Ribble Valley Borough Council
Housing & Development Control

Application no: **3/2023/0566**

Address: **Brentwood Pendleton Road Wiswell BB7 9BZ**

Proposal: **Proposed new vehicular access. Resubmission of application 3/2023/0038.**

Brentwood Site Plan

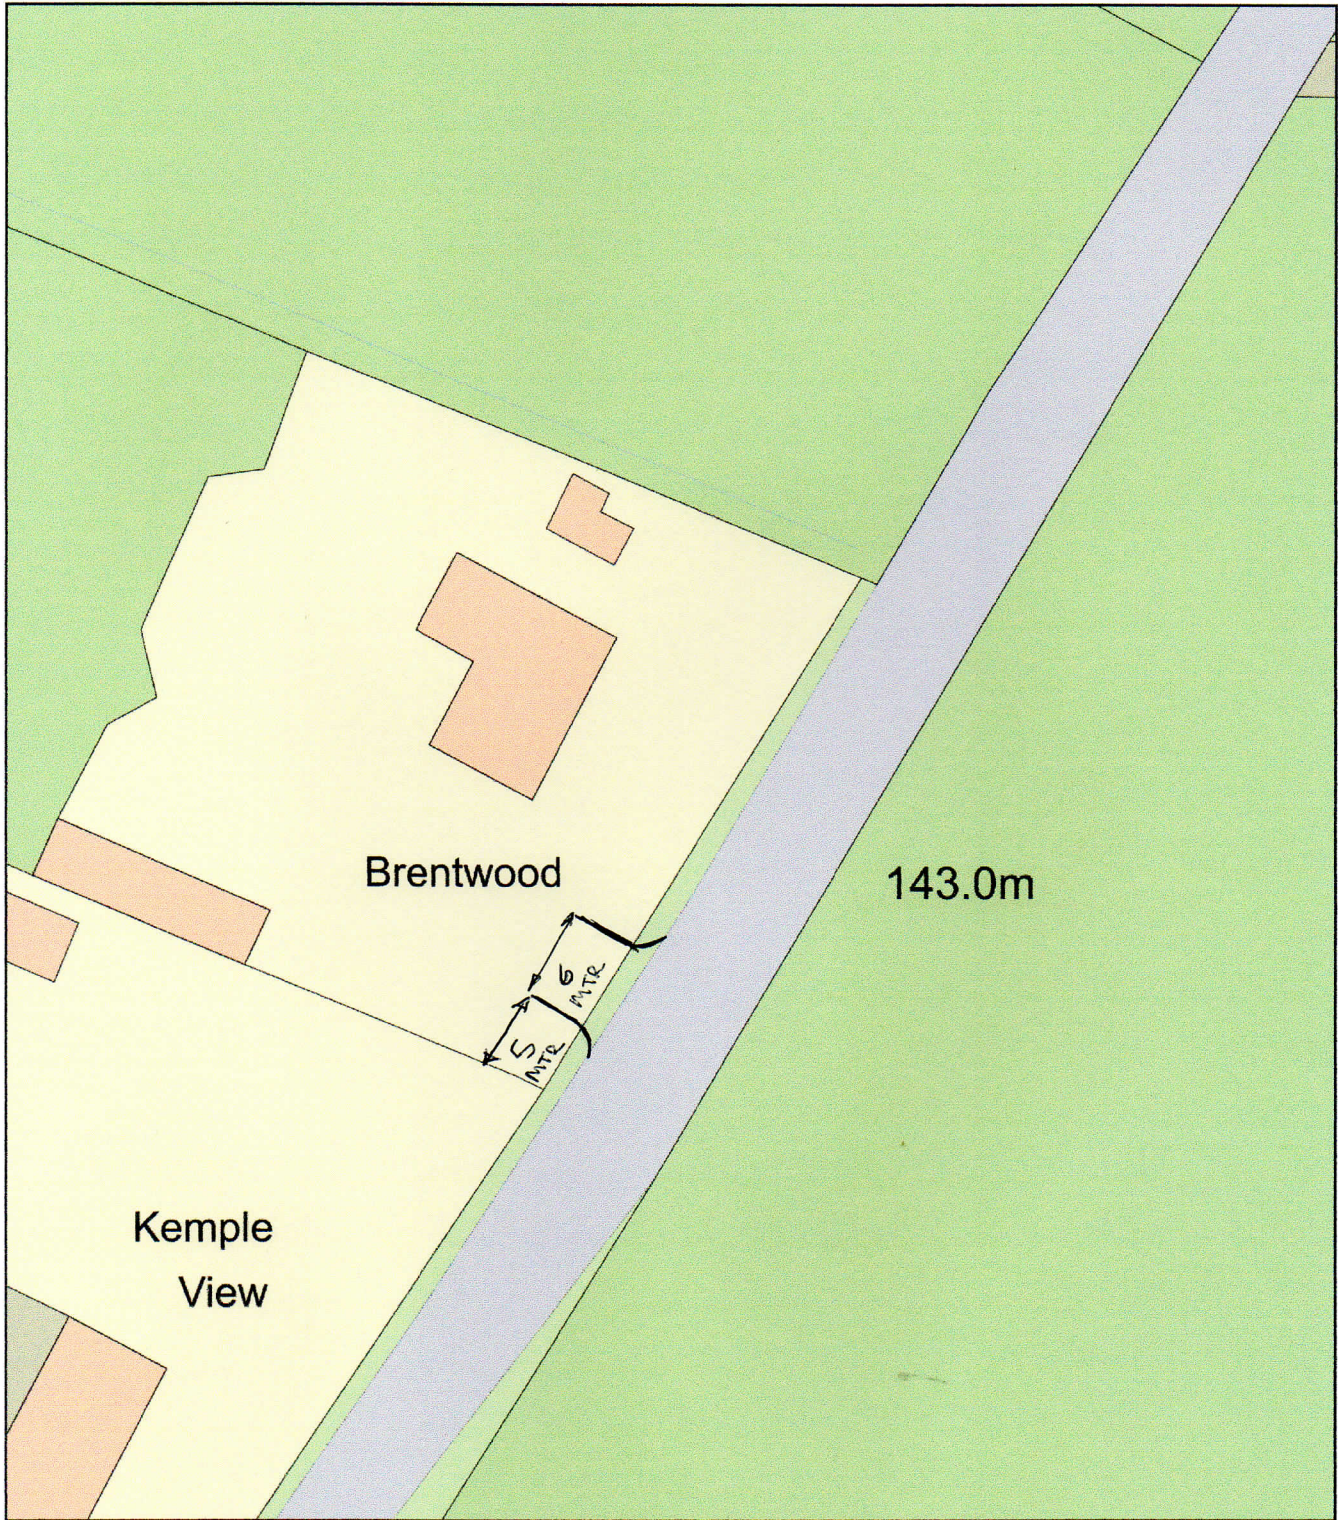
In any case, the LHA have reviewed PD drawing number 1463-02 Rev A titled "Proposed Layout Plan" and are aware that the access complies with the LHAs guidance.

The access is also able to achieve visibility splays of 2m x 43m in both directions, which were accepted during application reference 3/2023/0038 following a traffic survey being conducted within the vicinity of the site. Therefore, the LHA have no objection to the proposal.

1. No part of the development hereby permitted shall be occupied until such time as the access arrangements shown on PD drawing number 1463-02 Rev A have been implemented in full.

2. No part of the development hereby permitted shall be occupied until such time as vehicular visibility splays of 2 metres by 43 metres have been provided at the site access. These shall thereafter be permanently maintained with nothing within those splays higher than 1 metres above the level of the adjacent footway/verge/highway.
